6-26-01: Found deck; pool being installed w/ permits
Posted Stop WK order w/owner. NO

7/12/01 Inspected pool and deck. Footings appear to
be installed 4' deep - already backfilled. Reviewed
Guards/Rail Requirements, Pool Barrier codes. Pool needs
to be grounded, Label panel, Timer (w/mike c. & Tom M.)
will call when deck is ready JB

permit# 01-0799

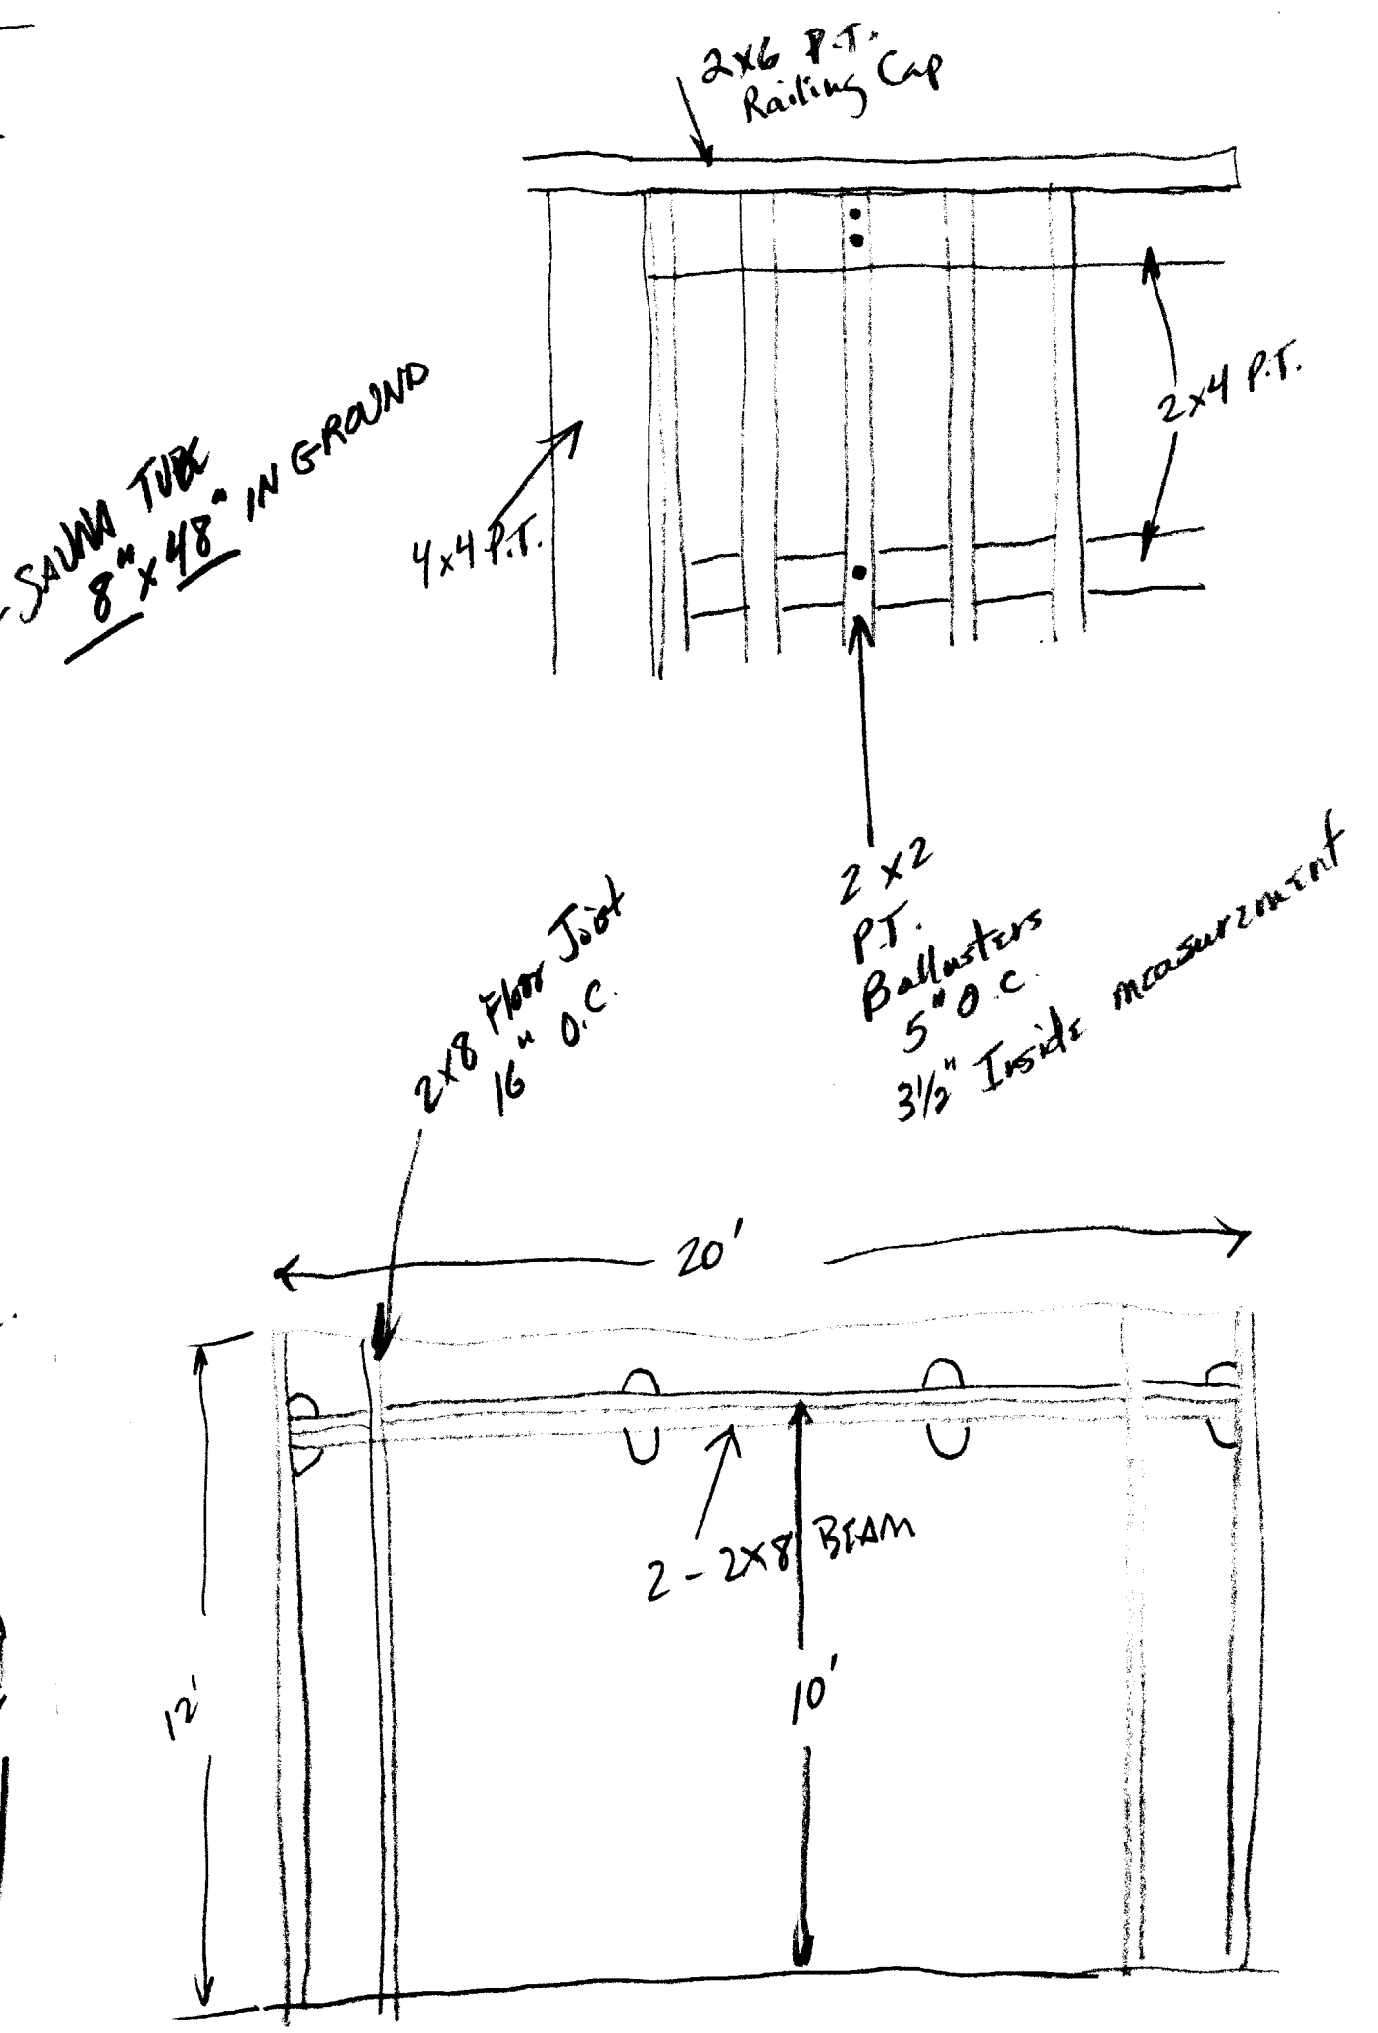
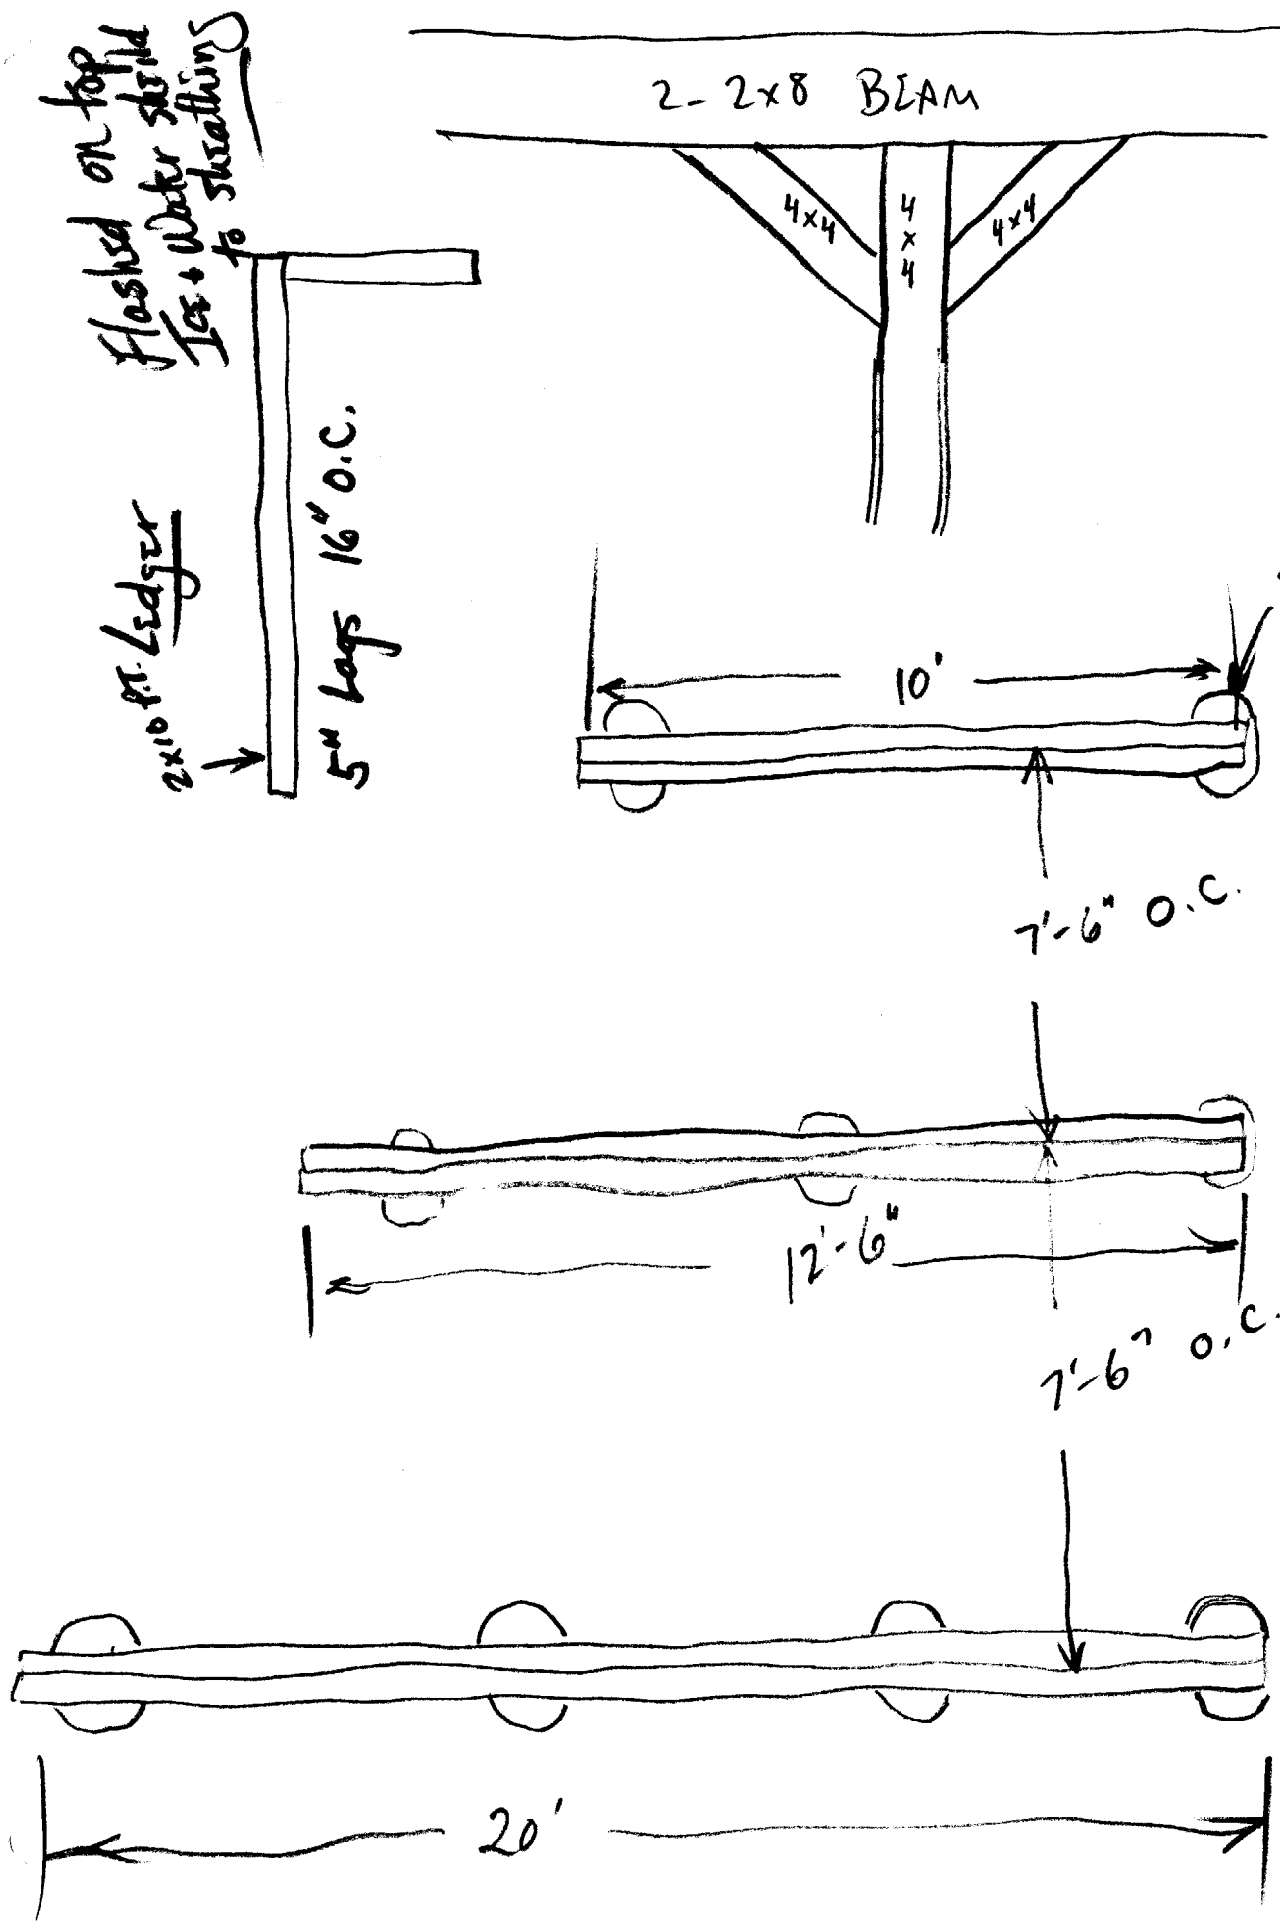
9/27/01 pool motor is still not grounded to pool
need H Rail (Grasp) down stairs, Guard Rails on deck
need to be completed, Gate to access pool not installed,
May need a Mid Rail at 7' Lattice privacy wall for
PSF strength, Gussets on Butt joints of Joists landing
on beam, Need 2x8 ledger support at curve @ pool
for joists, Rim joist at rear end of Deck. JB

4/26/02 - Final deck inspection & pool - all above
items have been taken care of and no other
deficiencies noted. Close out
